**Re: Planning Application ref: 23/01451/FUL**

**For:** Additional fourth storey to accommodate 3 x 2 flats

**At:** Friars Garth, The Parade, Epsom Surrey KT18 5DH

Third Floor Plan
1.100 @ A1

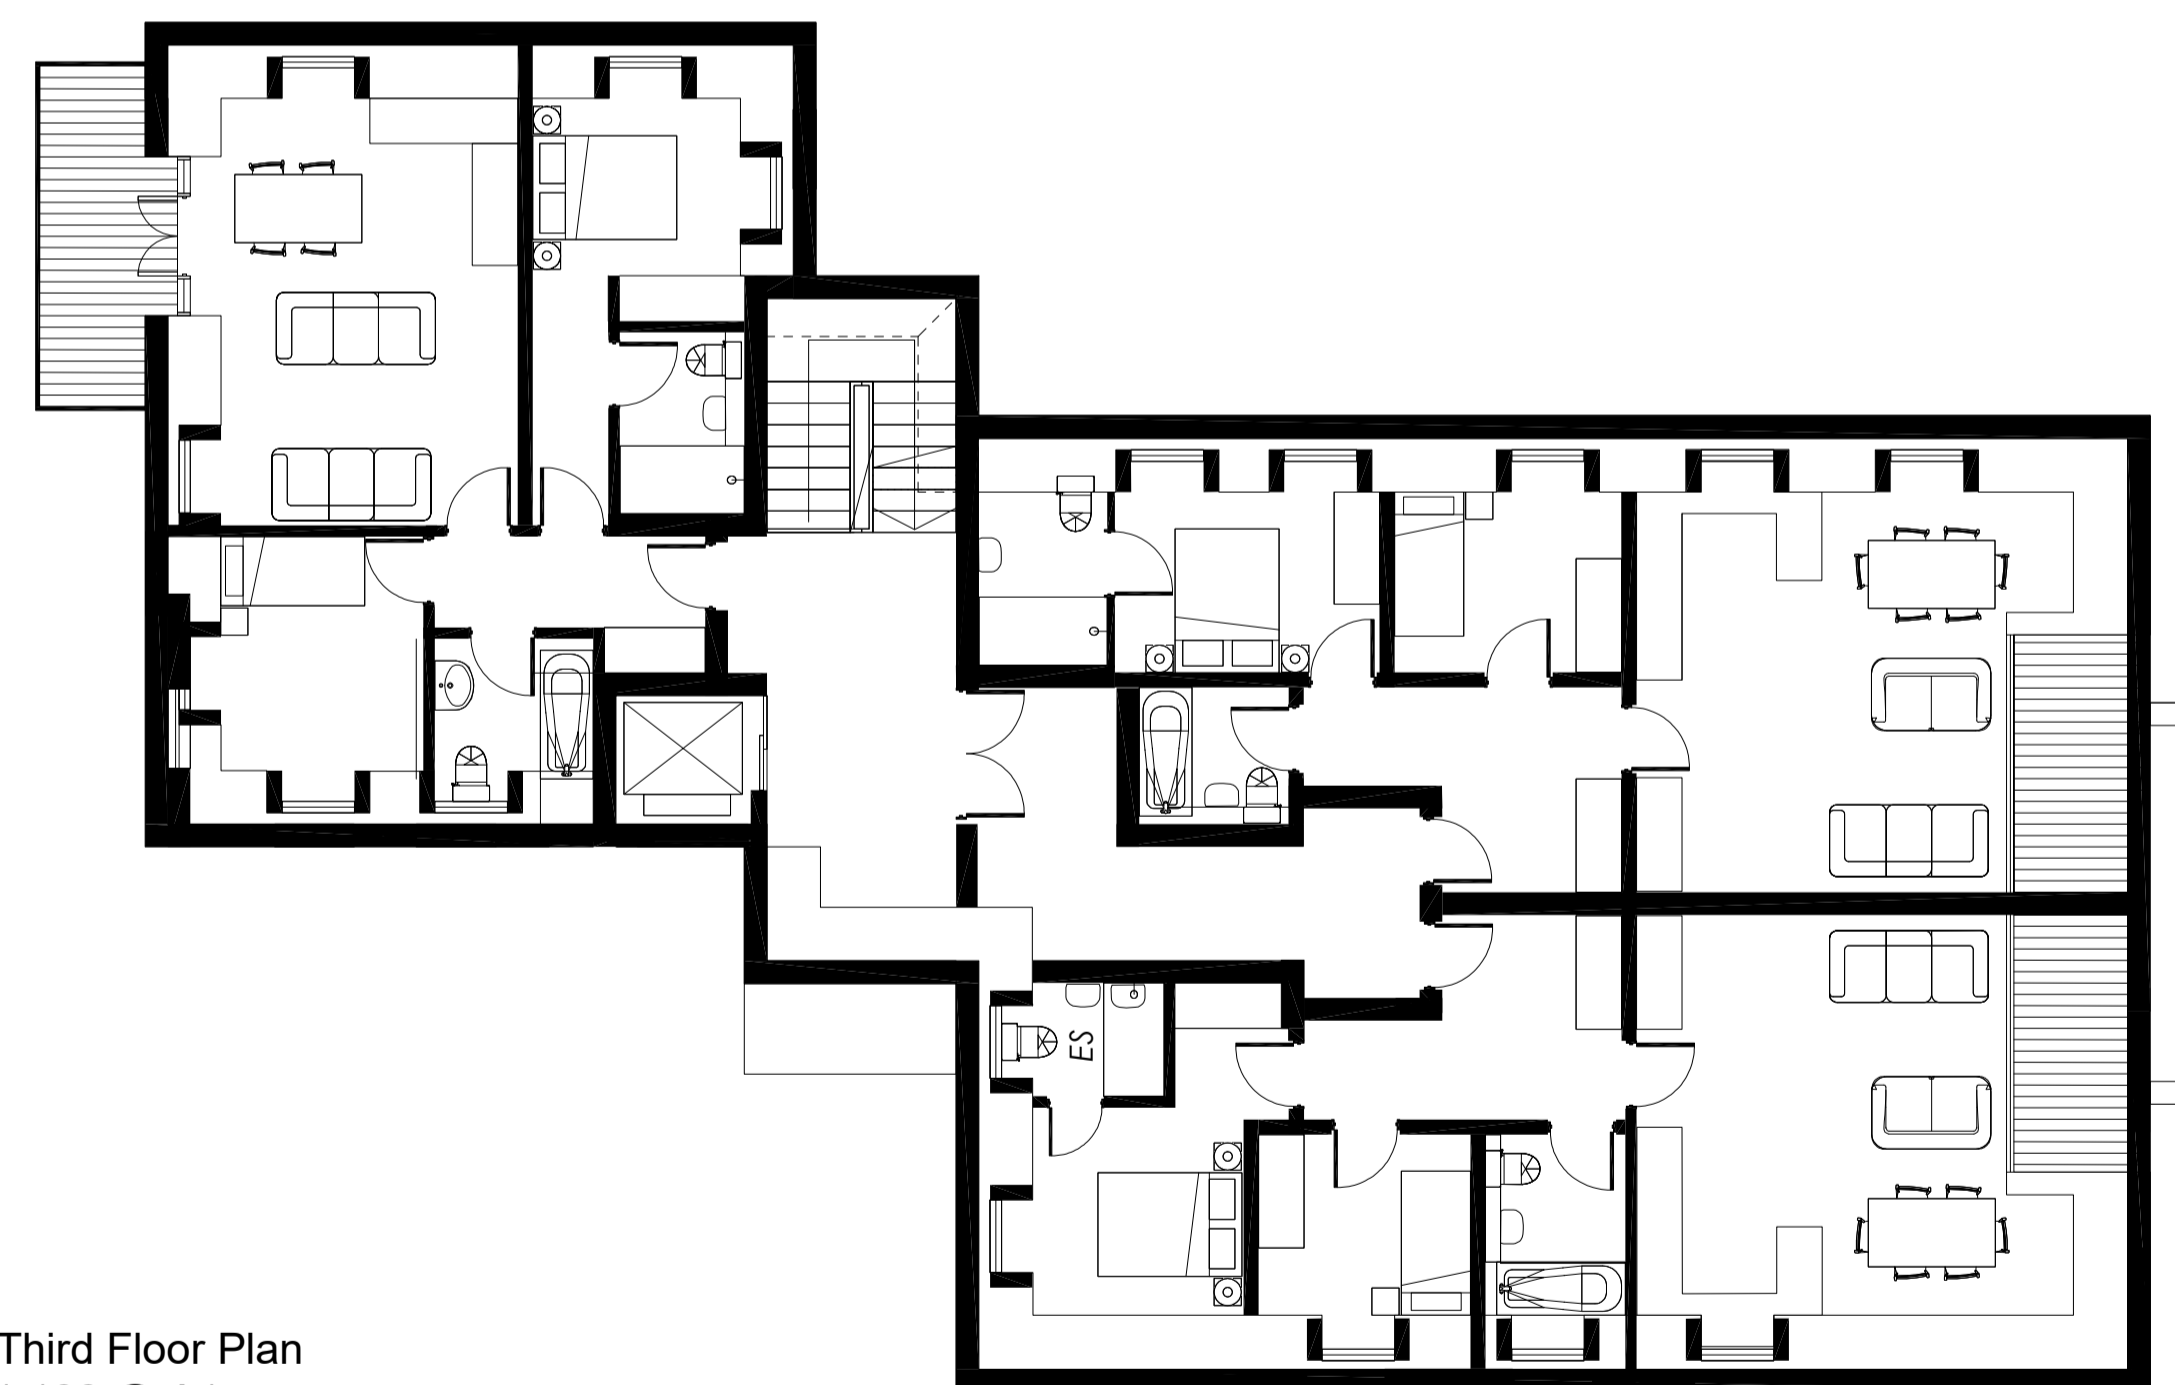
The additional fourth storey would breach Local Plan (S12.1a and S12.1d) by not respecting the scale and character of the local area, and by compromising neighbouring properties with loss of light with the height of the building and additional loss of privacy through overlooking windows.

The new proposal to build an additional storey will result in an overbearing structure that is significantly taller than other local buildings. An earlier application to build a property with 4 storeys (Reference 20/01229/FUL) was withdrawn by the previous developer as it was recognised that the height of the building would be out of keeping with the local area.

The current design for the new (partially constructed) development is already taller than the neighbouring town houses on The Cressinghams and other buildings on The Parade. An additional storey will make the new build even more out of keeping with the local area, which is located within very close proximity to two Conservation Areas and a Grade 2 listed building (the Pines). The plans of proposed elevations and street scene are not to scale so give a false impression of the height of the new proposal.

The addition of an extra storey will result in a greater loss of privacy and light for neighbouring buildings on The Cressinghams, which has already been significantly compromised by the new development. The increased density of occupation, from 9 flats to 12 flats will further impact on noise and disruption for existing residents.
